Rezoning Transportation Analysis

Petition Number: 2022-210

From: Jake Carpenter, PE
Jacob.carpenter@charlottenc.gov
980-221-5675

Date	Description
05-24-2023	First Review (PDM)
06-21-2023	Second Review (DR)
08-23-2023	Third Review (PDM)

RZ-03

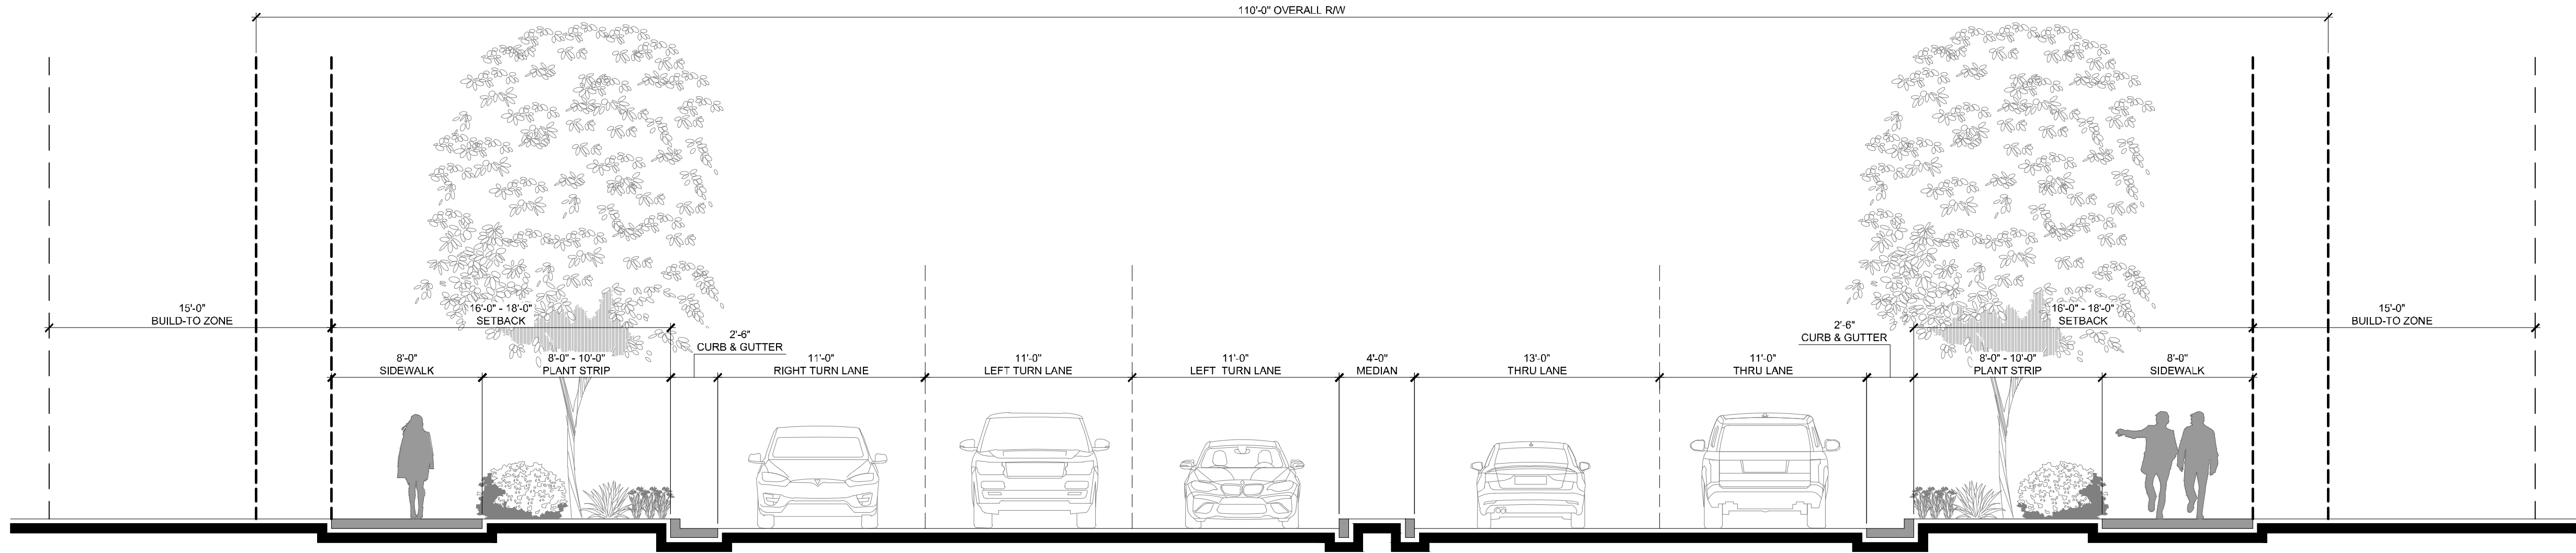
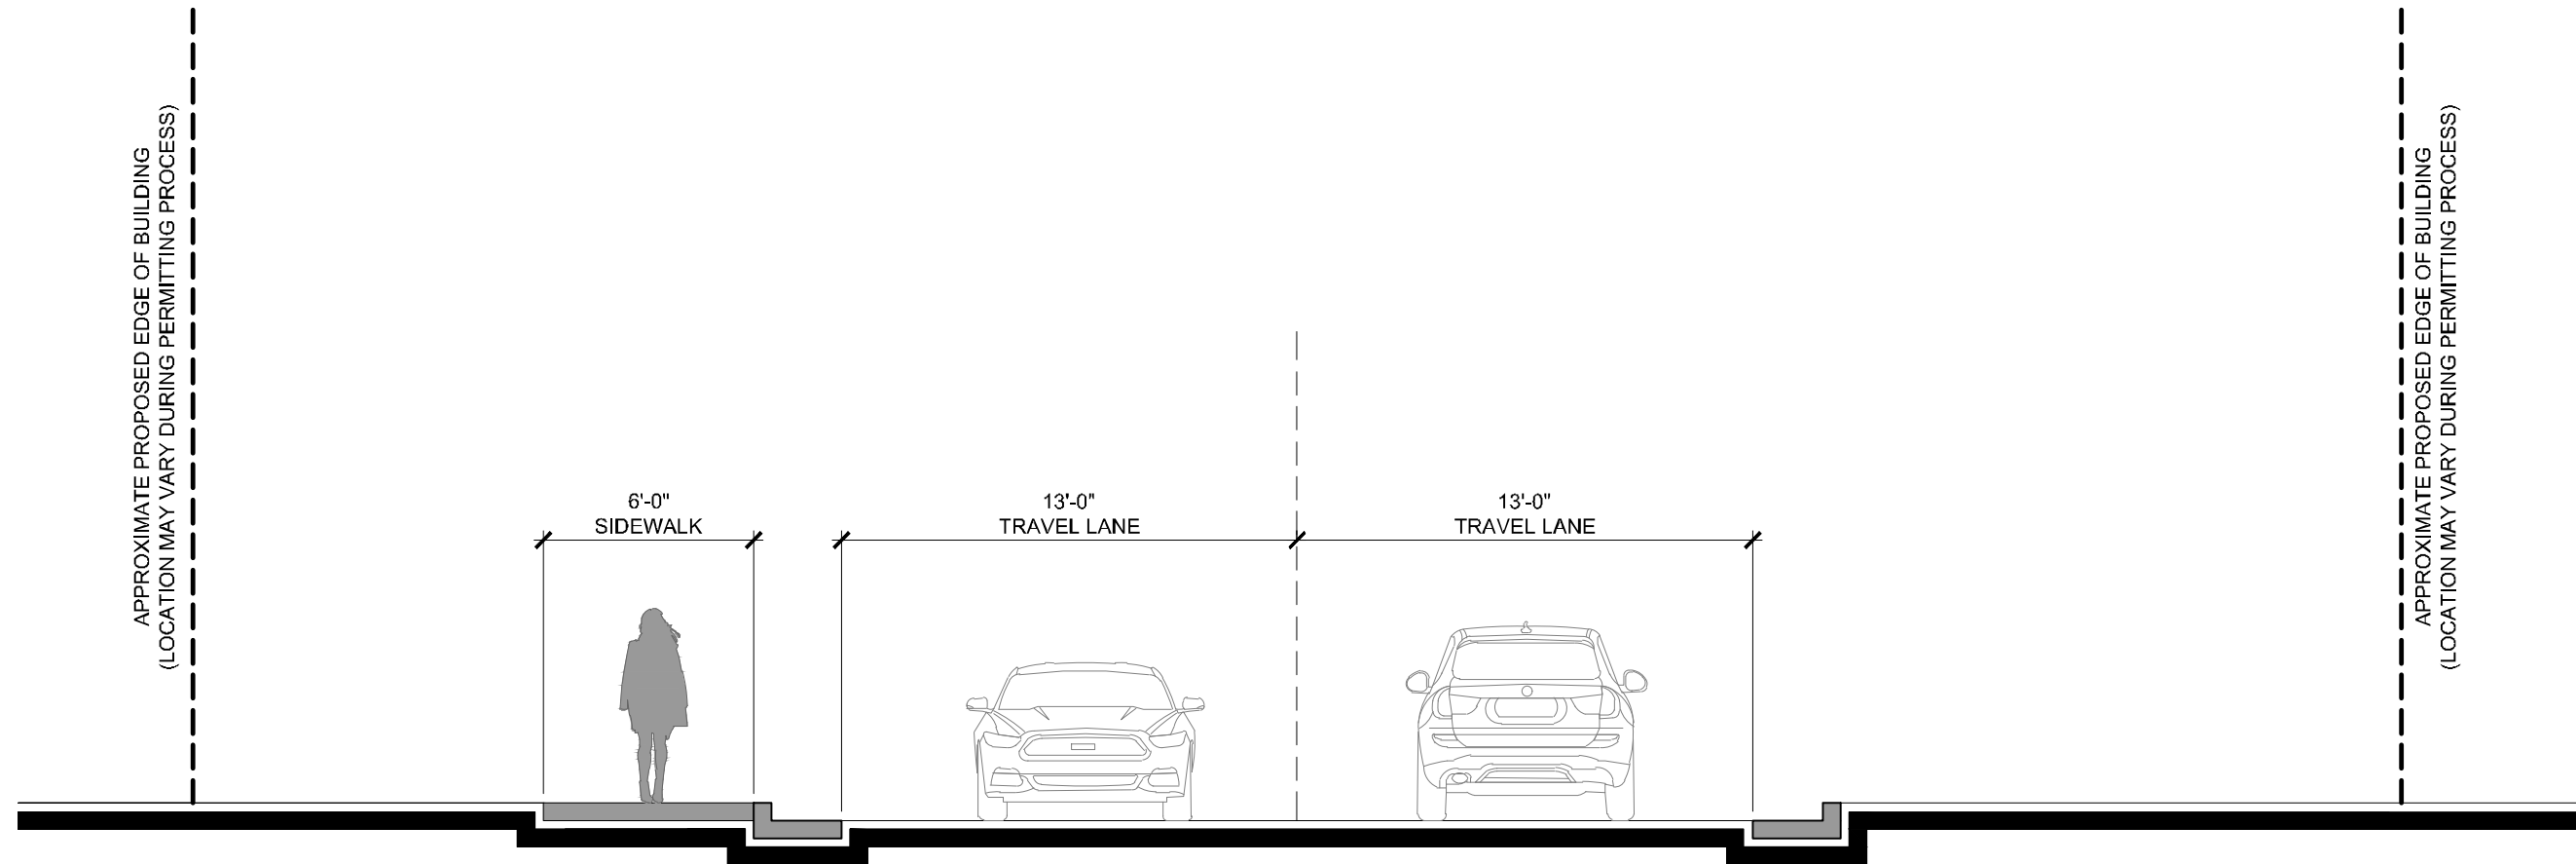
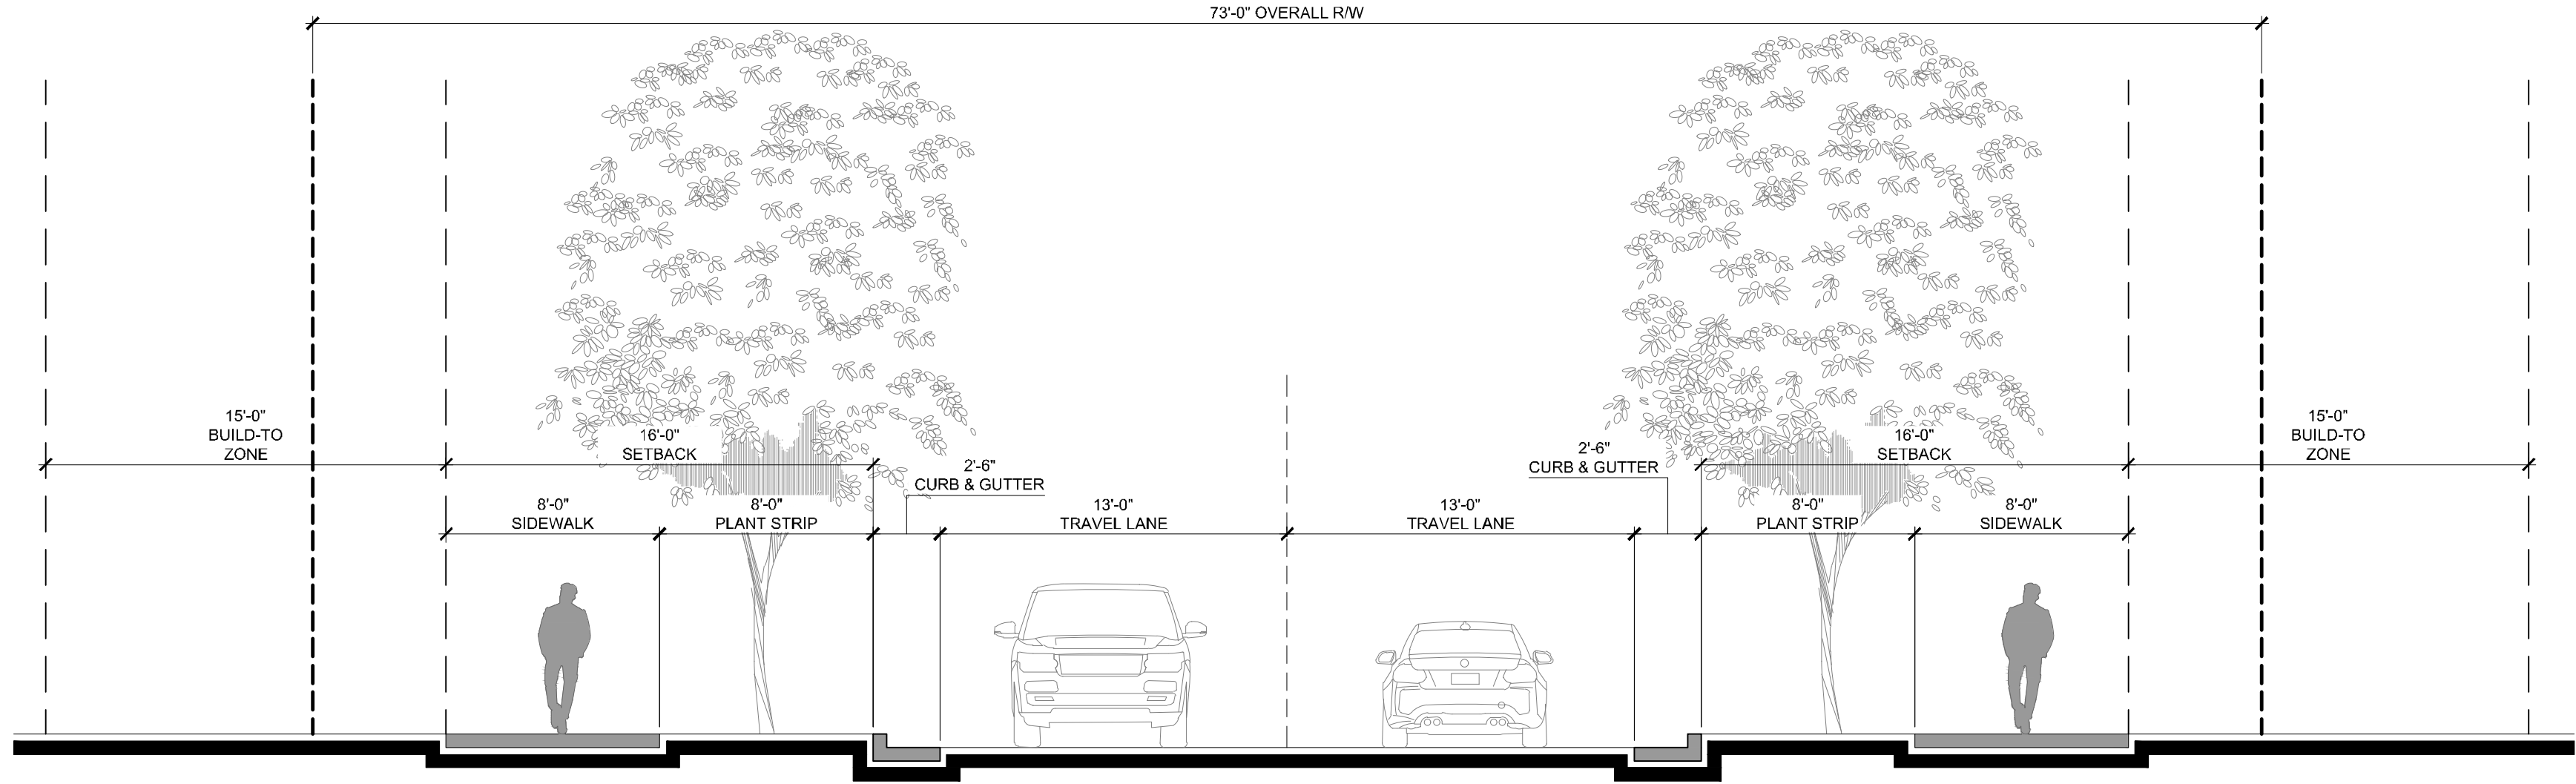
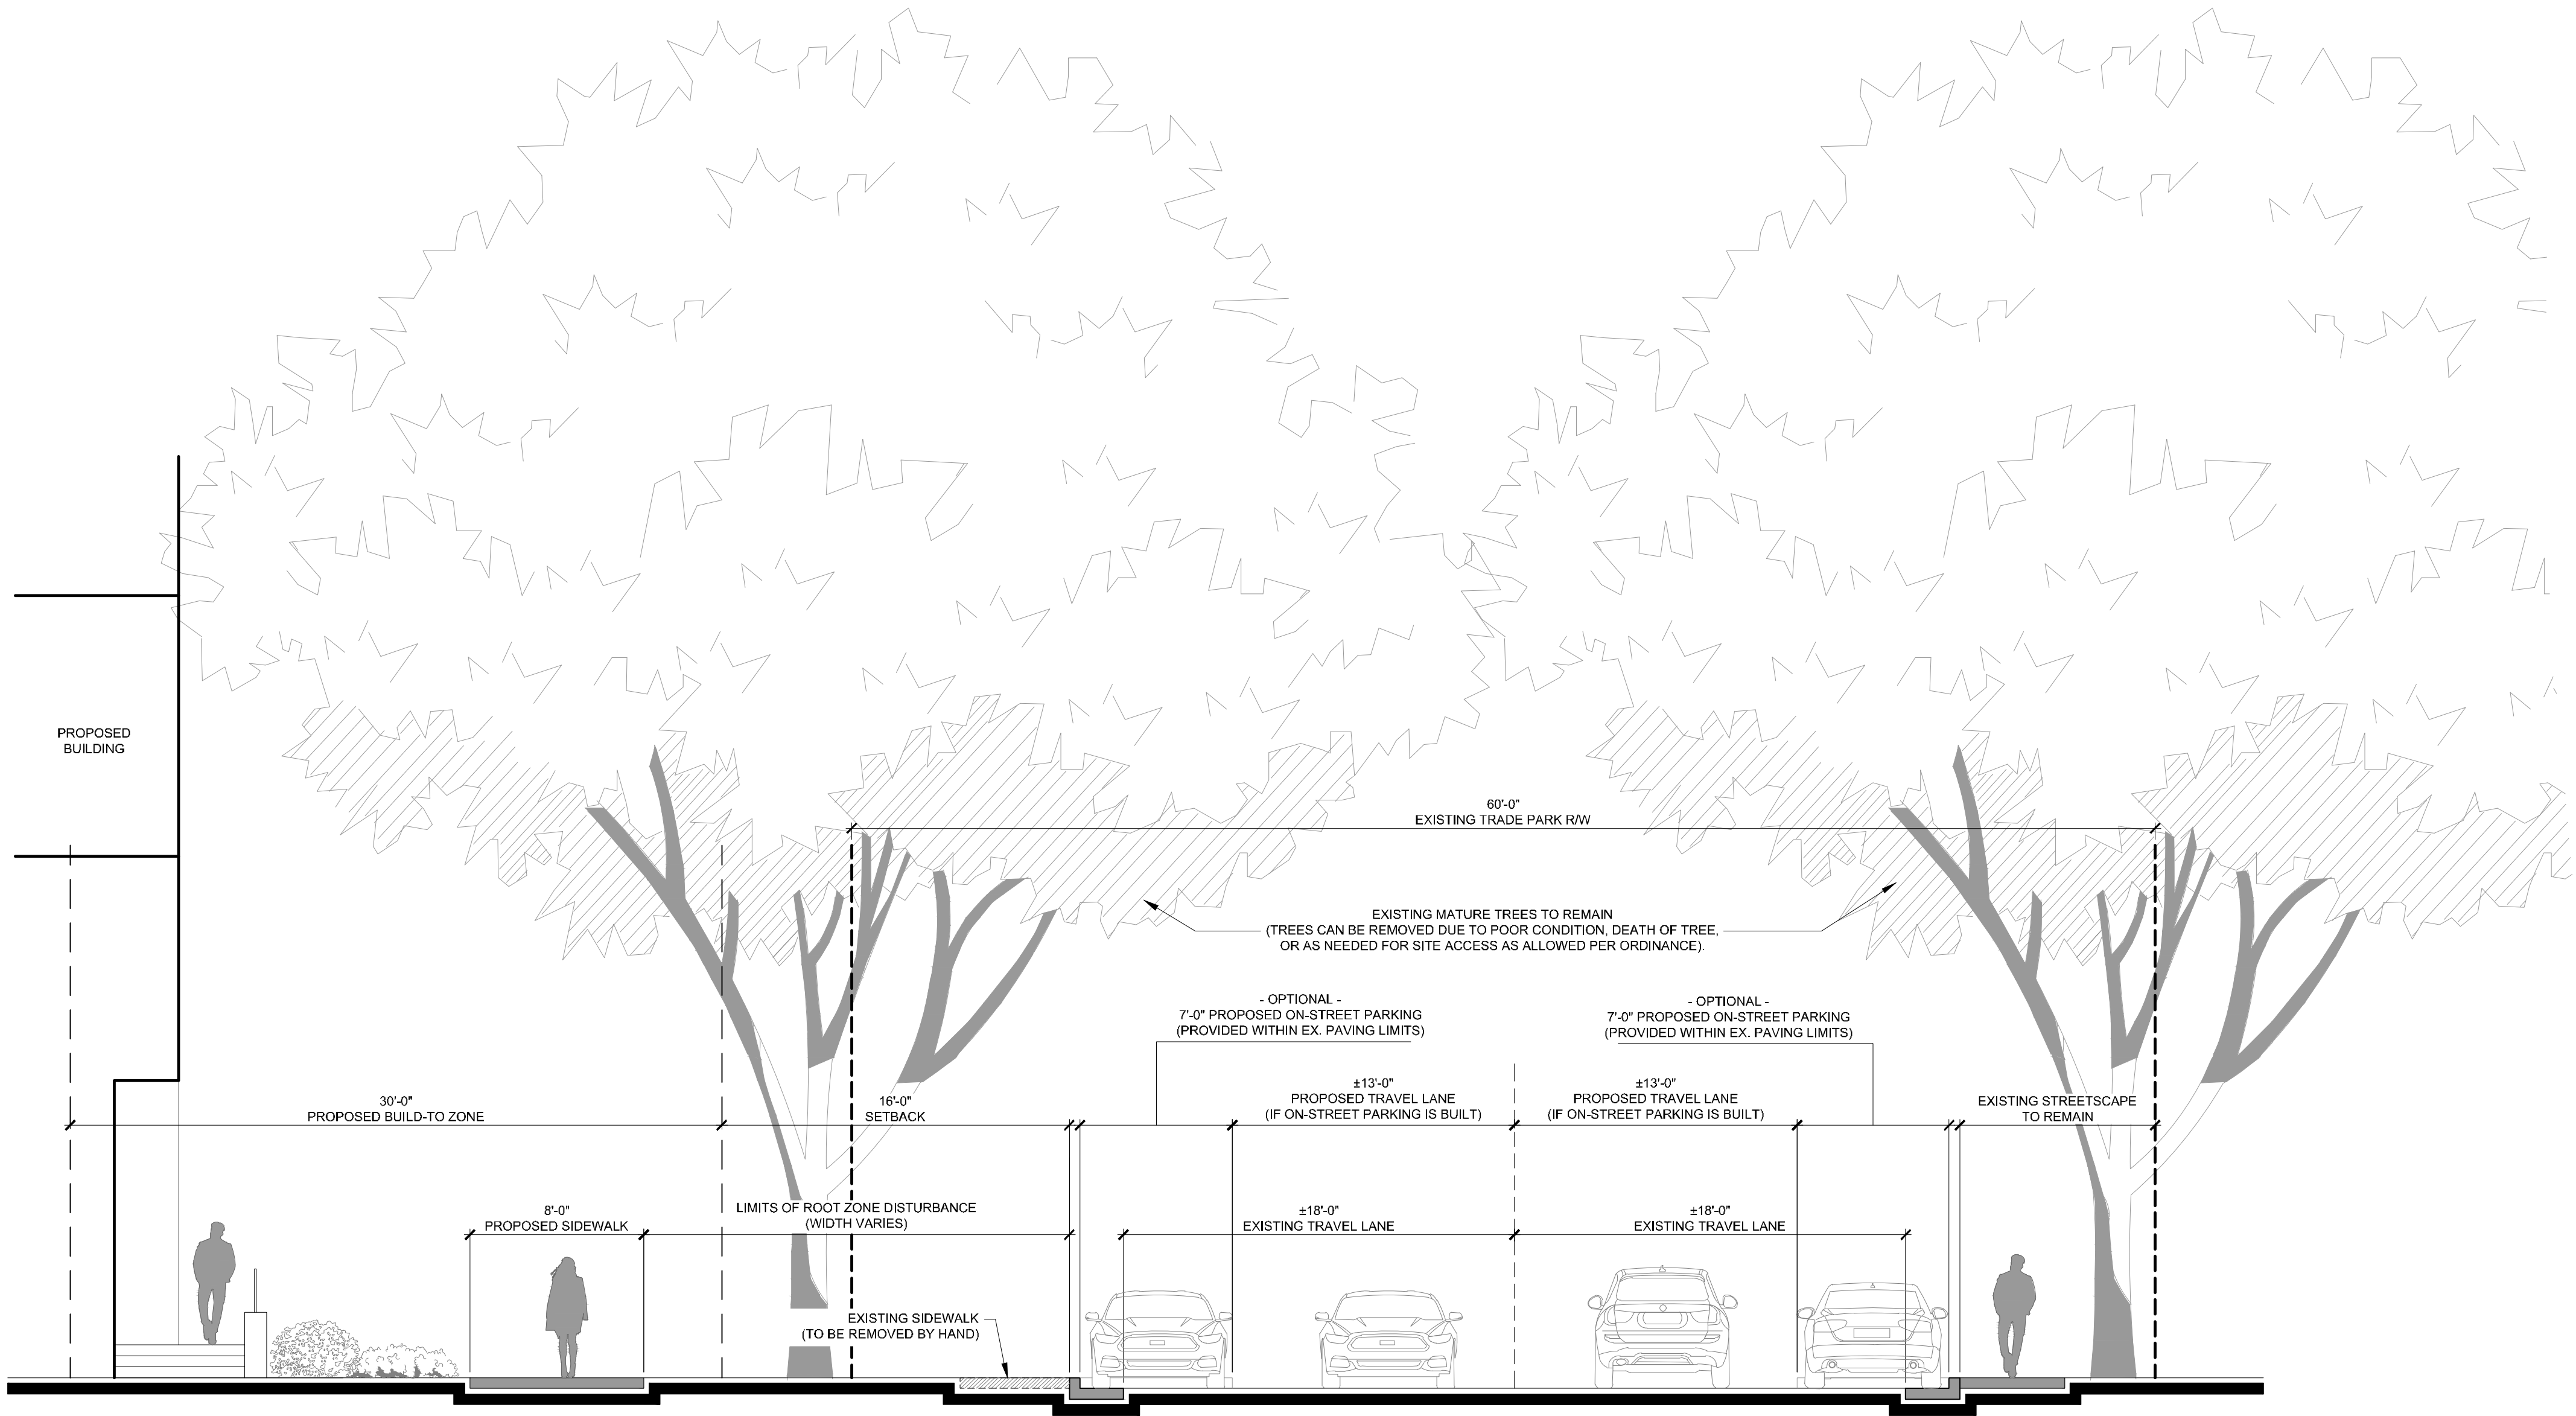
6. Revise internal street network to standard public street typical sections per the CLDSM or provide additional information on existing constraints for review and approval of nonstandard typical sections.
